RE: Planning Application - AW/164/21/OUT – 14 Princess Avenue – Aldwick

Please take this letter as formal notice of our strong objection to the above planning application which seeks to convert an existing single family dwelling into four flats.

Proposed Site Layout Plan at 1:100 scale

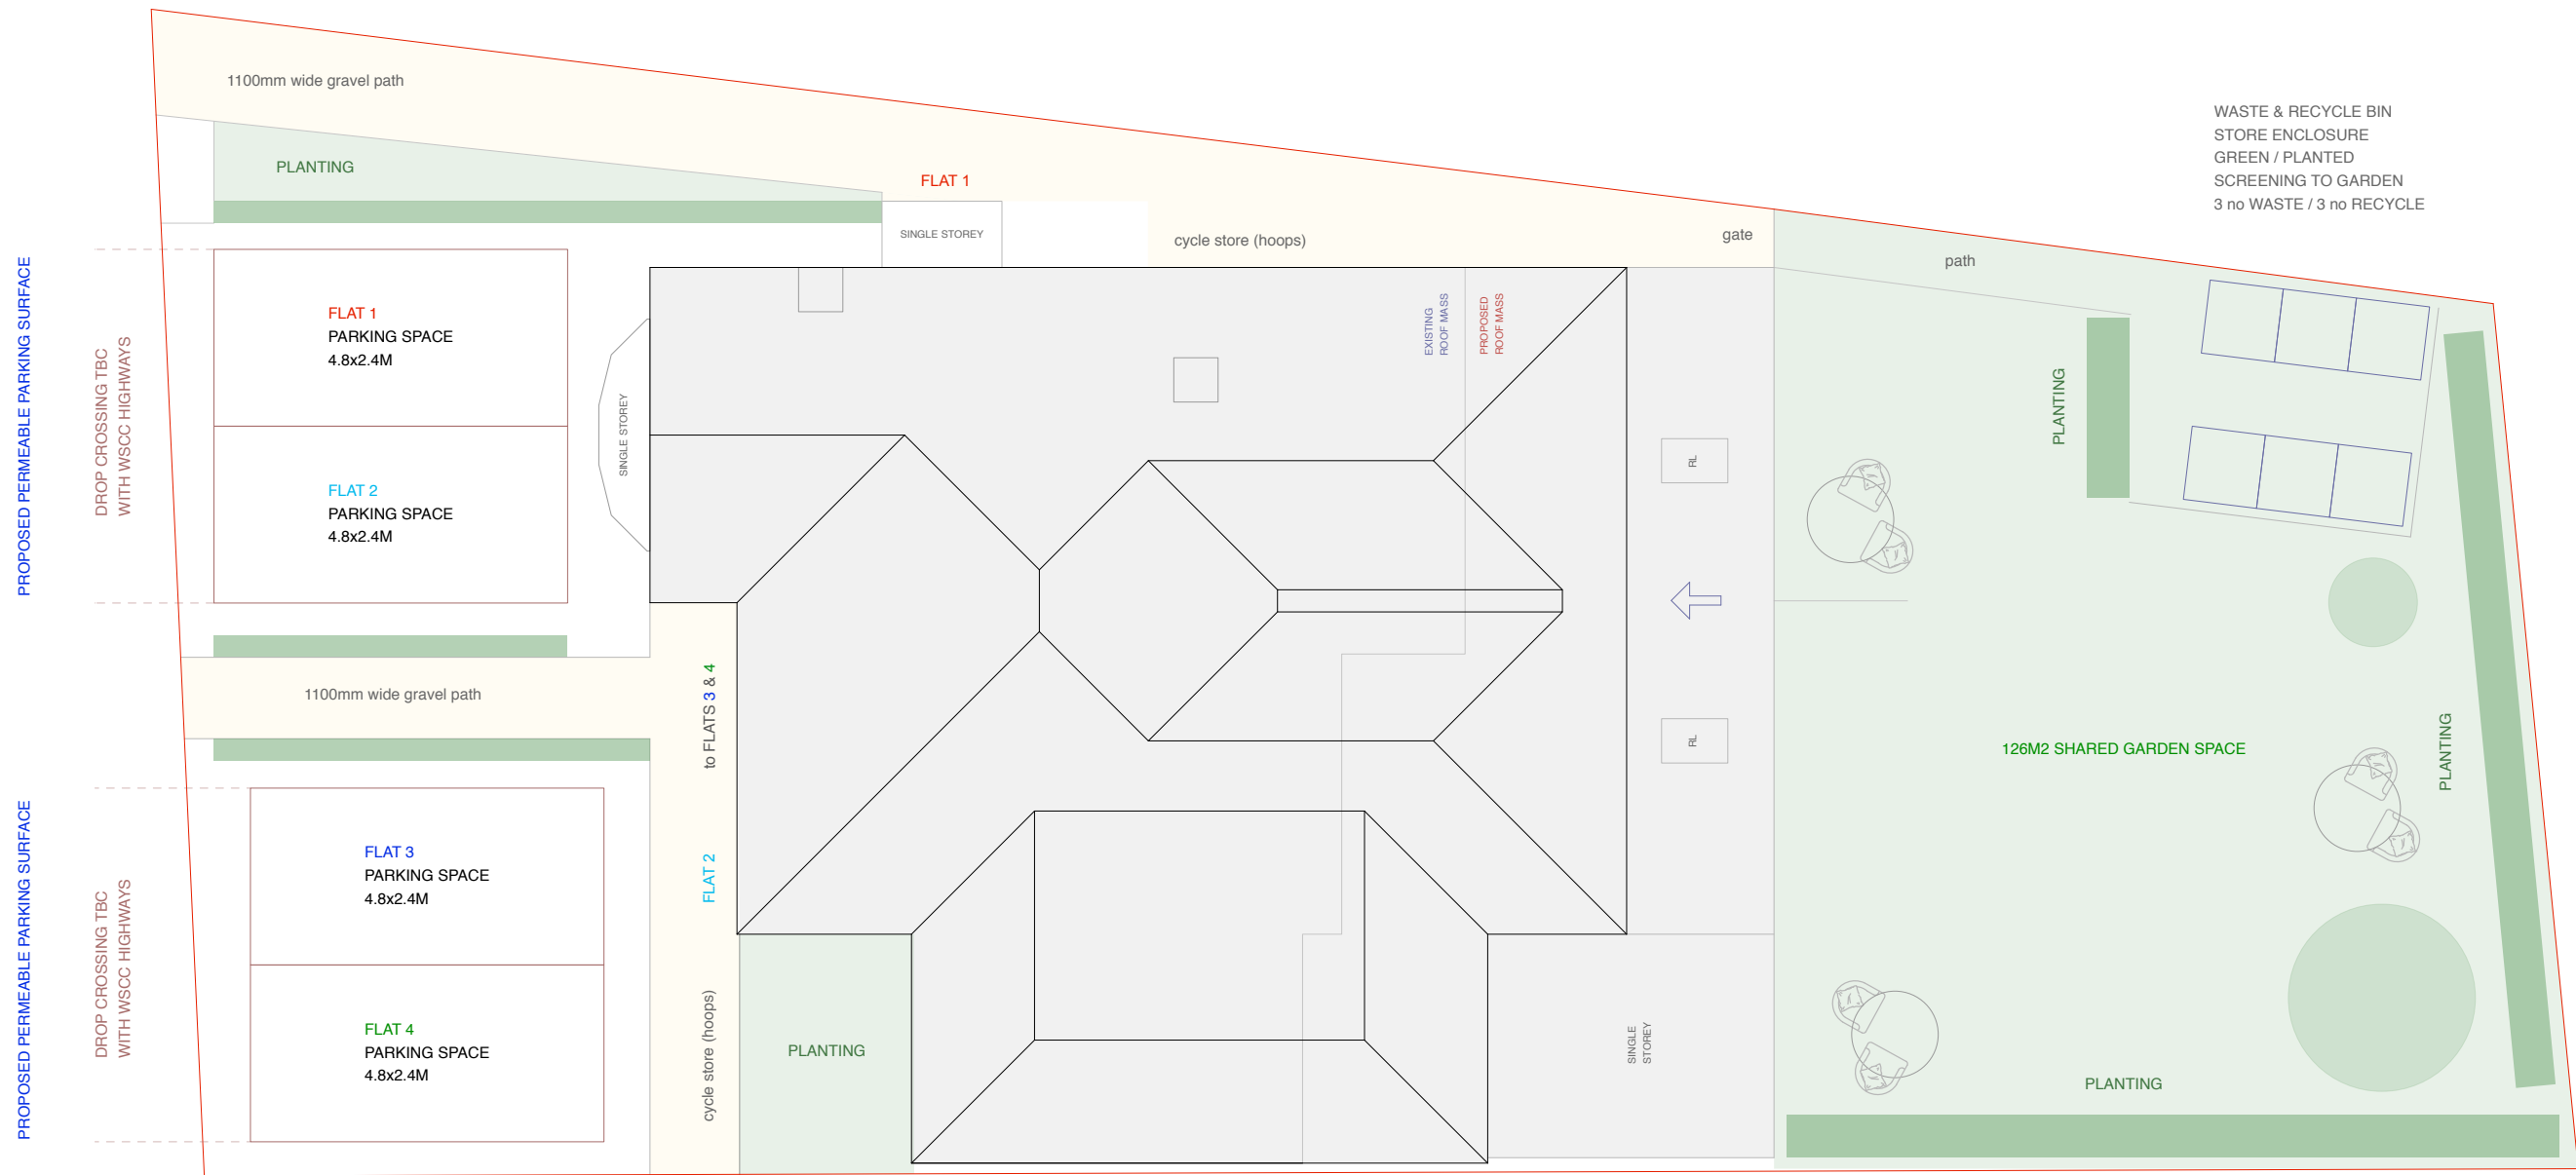
In support of their application the Applicant has submitted a Drawing No 8 - Proposed Site Layout Plan. The drawing shows at the northern side of the 'Shared Garden Space' a Waste and Recycle Bin Store.

Each week the occupants of the four flats will be required to take four black Waste Bins from the bin store in the rear garden to the road frontage of 14 Princess Avenue and back. Each single bin journey will be twenty-eight metres from bin store to road. The round trip for each bin will therefore be some fifty-six metres or 280 metres for all five bins.

Every second week the occupants will manhandle 8 bins – Waste and Recycling- from the bin store in the rear garden to the road and back. This will generate a collective noise undoubtedly in excess of the 97 Decibel figure. This noise will far exceed the 'over 72 decibel' level of Noise Exposure Category D – the level where planning permission should normally be refused.

There are trees in both front and rear gardens at 14 Princess Avenue. It is clear from Drawings 8 - Proposed Site Layout Plan from both front and rear gardens that all trees and grass are to be removed in order to 'Tarmac over' the whole of the front garden for car parking which is counter to the character and appearance of the area. In the rear garden the trees next to the north wall of the garden will need to be completely removed in order to build the Waste Bin Store and the Cycle Store as shown in Drawing No 8 – Site Plan.

The wholesale wiping out of the trees to make way for a bin store at the rear of 14 Princess Avenue would be a ecological disaster for garden birds in 14 Princess Avenue. There are birds that nest in the mass of trees in the back garden of 14 Princess Avenue every year. Fledgling birds raised in the gardens of these Avenues fly to the trees in the rear garden of 14 Princess Avenue to feed on insects and sustain themselves. All the trees in the front and rear gardens of 14 Princess Avenue provide essential shelter and food for birds.
